Beacon Fen Energy Park – Development Consent Order

Application reference: EN010151

Document: Deadline 7 – Response to the Examining Authority’s Third Written Questions (ExQ3) (issued 26 January 2026)

Questions answered: NED.3.1 and CA.3.2

ExD 7.2 [ExD4.8]

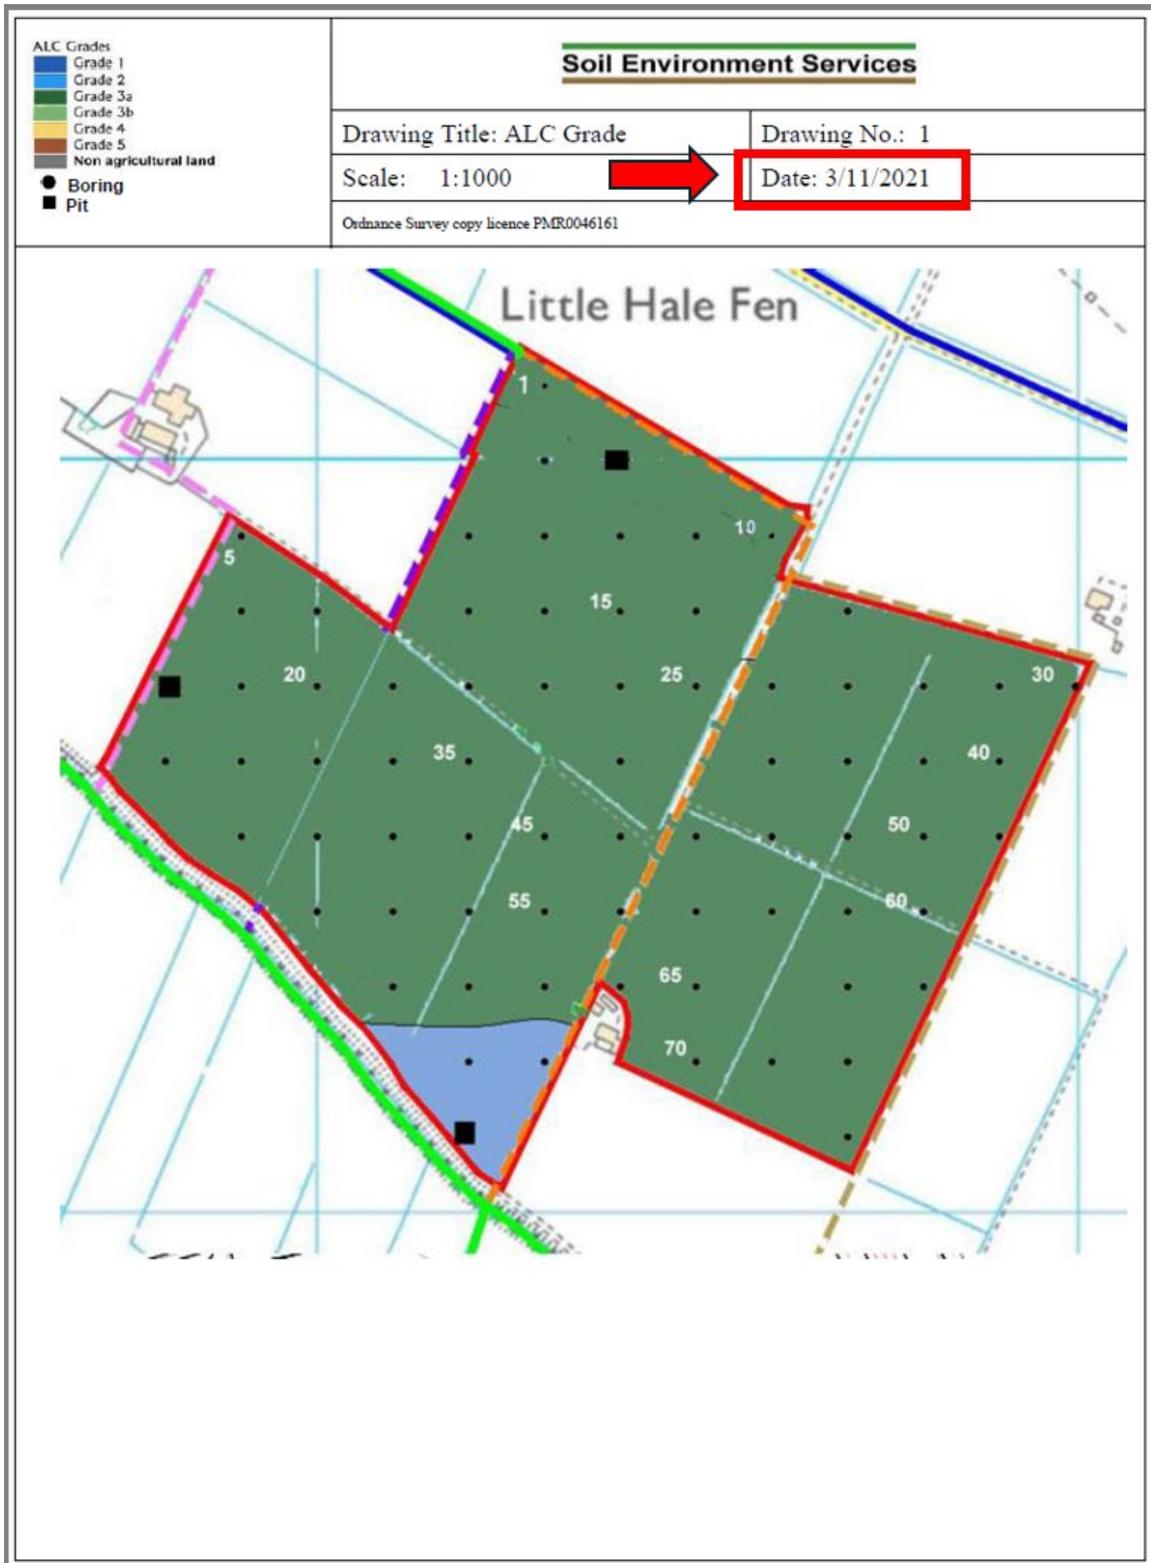
16. The Applicant's approach risks flattening meaningful agricultural differences into desk-top labels. LCJM has repeatedly explained the on-the-ground distribution of sensitivity (e.g. irrigated potato rotations and drainage vulnerability), yet this has not been transparently integrated into route comparison in an auditable way.
17. LCJM also relies on local ALC evidence (including the AGR3 ALC survey material) demonstrating that desk-top mapping can be materially misleading where land quality is decision-sensitive and that targeted verification is required. **ExD7.2, ExD7.3 and ExD7.4.**

ExD7.9 [ExD4.12]

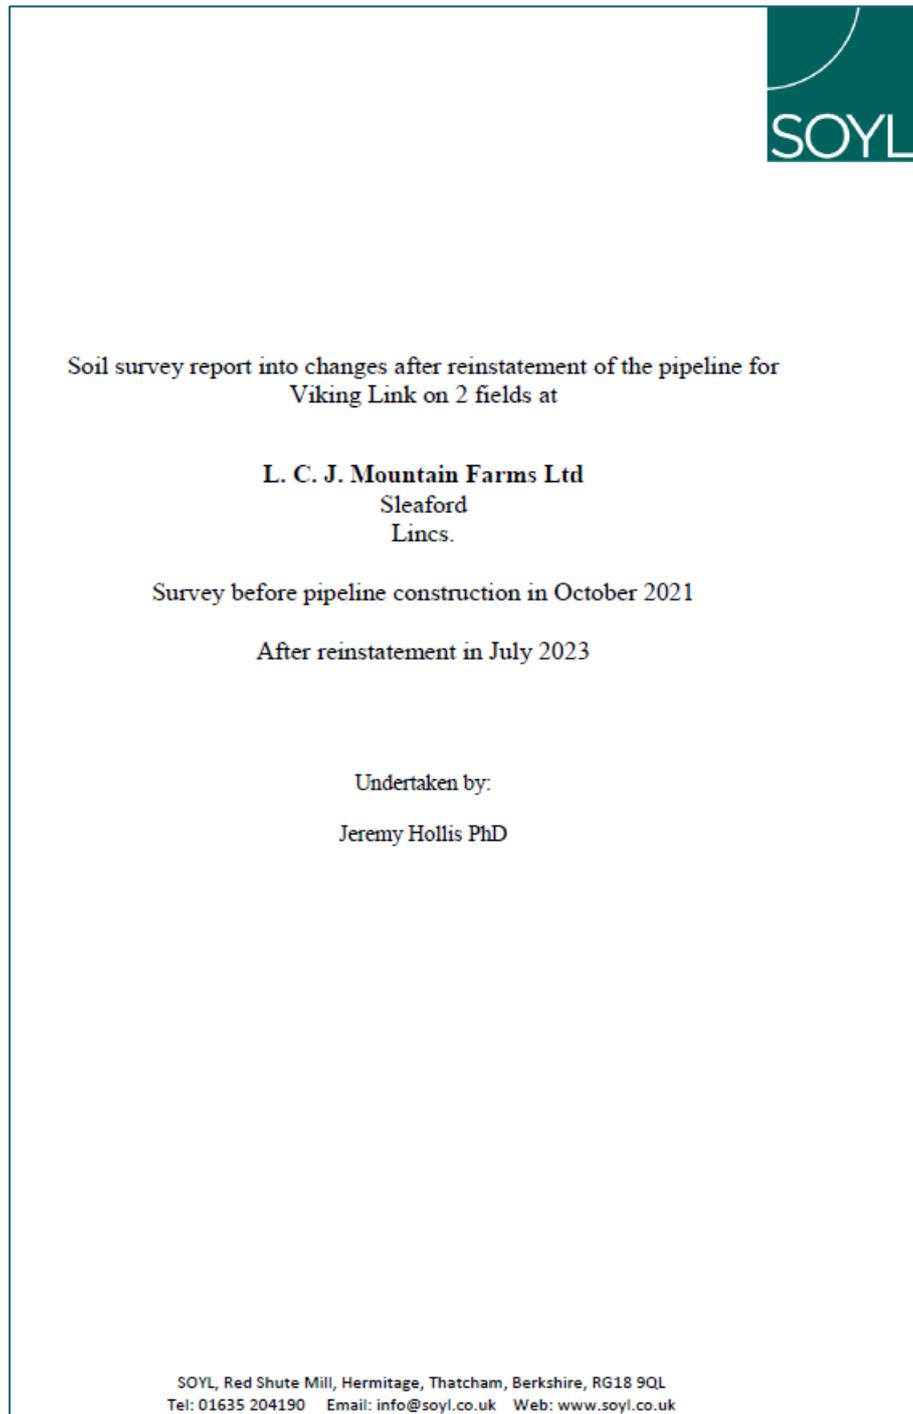
- **Evidence and what LCJM asks the ExA to do:** LCJM relies on ExD7.9–ExD7.15 (mechanism-based; not a compensation quantum case). LCJM asks the ExA to require a short auditable addendum (defined auditable deliverables) so the comparison can be independently verified and made like-for-like (including logistics), and to treat CA/TP as a last resort where a programme-neutral voluntary agreement route (provided by LCJM in November 2025) remains live—capable of removing delivery risk while securing enforceable, farm-specific protections and audit-grade deliverables.

ExD7.16 - Applicant public consultation figure: Local Wildlife Sites mapping (illustrating symbology/emphasis and auditability concern)

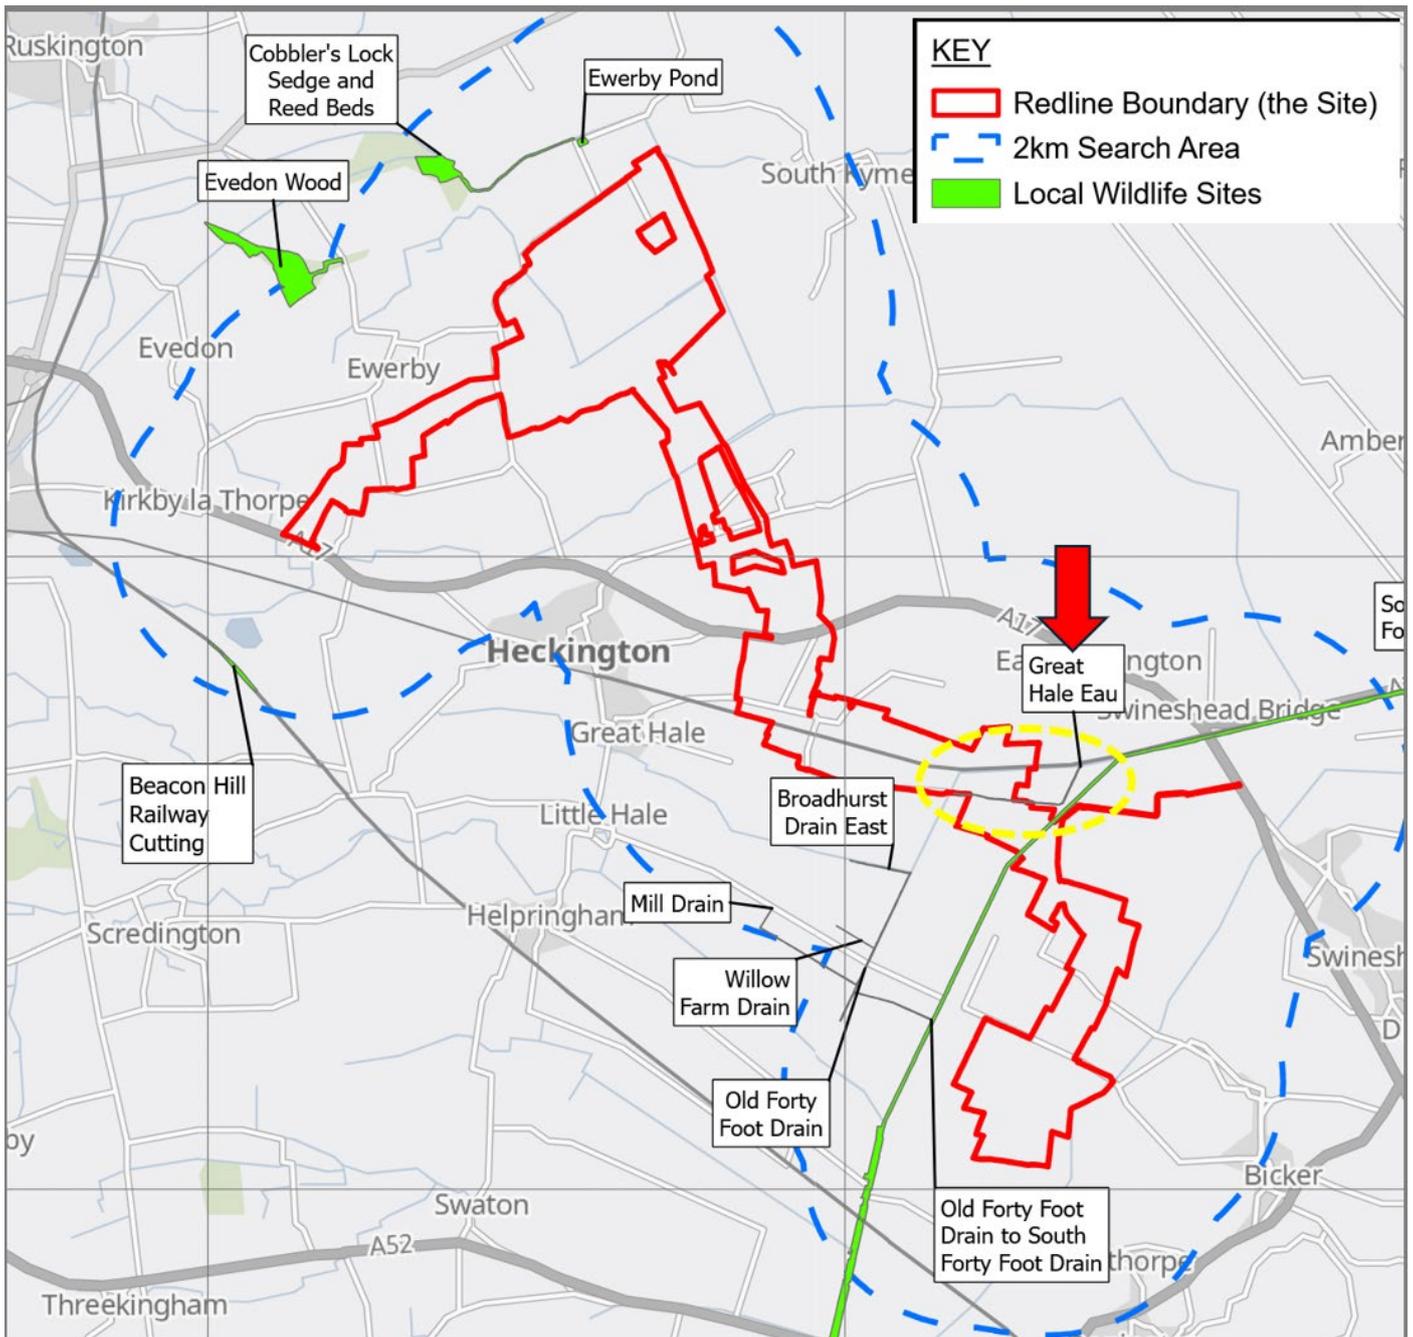
ExA to determine intent; the issue is auditability and consistency of presentation (Applicant consultation mapping: Local Wildlife Sites figure – ExD7.16).

20. LCJM invites the ExA to require the Applicant to provide a GIS-based schedule and map pack showing all LWS interactions for: (i) the cable corridor; (ii) temporary possession; and (iii) access/haul routes and compounds — using consistent symbology.

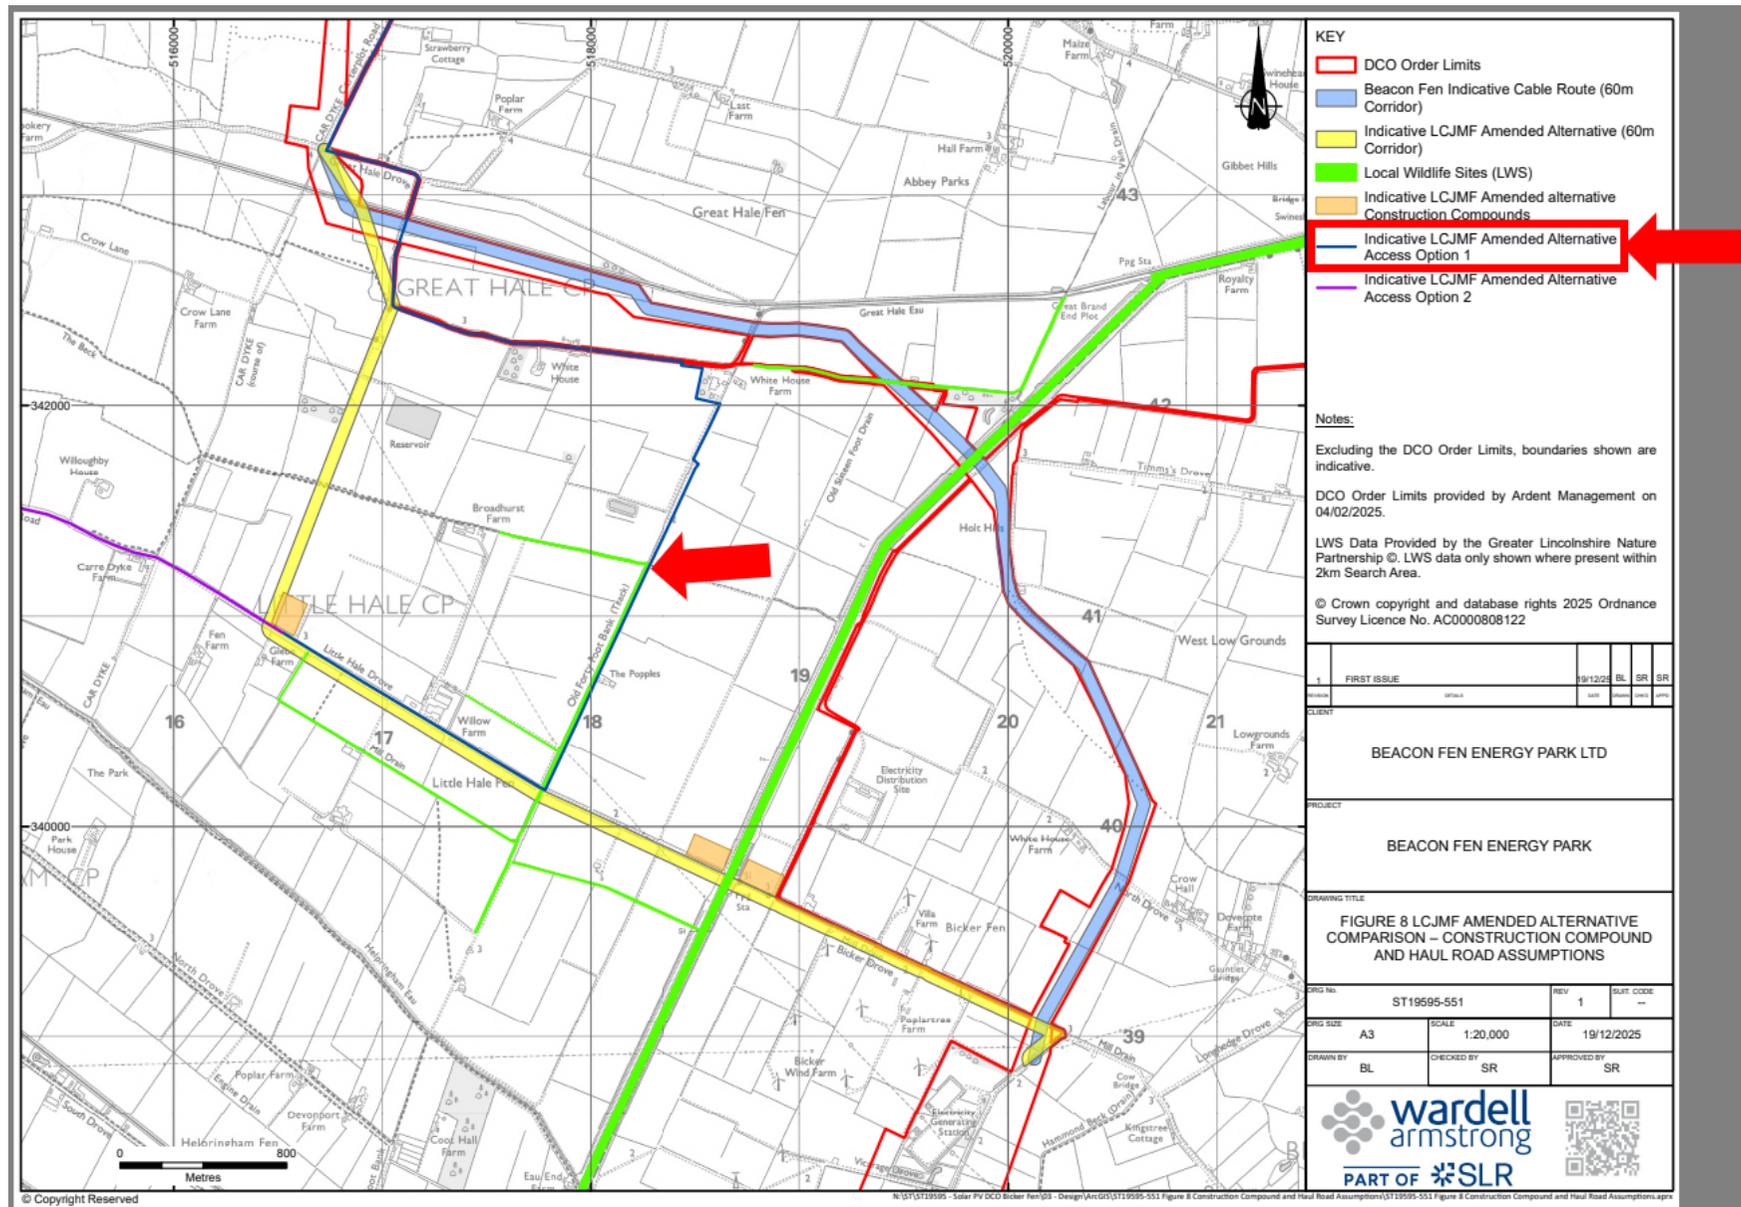
2. By way of example, in its comparative ecology narrative the Applicant introduces a hypothetical internal haul/access alignment for the LCJM Hybrid ("Access Option 1") running longitudinally along/adjacent to the Great Hale Eau Local Wildlife Site (LWS 4490), thereby maximising the stated "parallel within 50m of an LWS" lengths and then deploying those figures to score the LCJM Hybrid adversely. LCJM has not offered that internal private haul route and has not agreed it is available for construction traffic. Further, even on an "assumptions" approach, a materially less intrusive alignment is plainly available (including the alternative shown by LCJM which avoids longitudinal LWS interaction). [ExD7.17–ExD7.18]
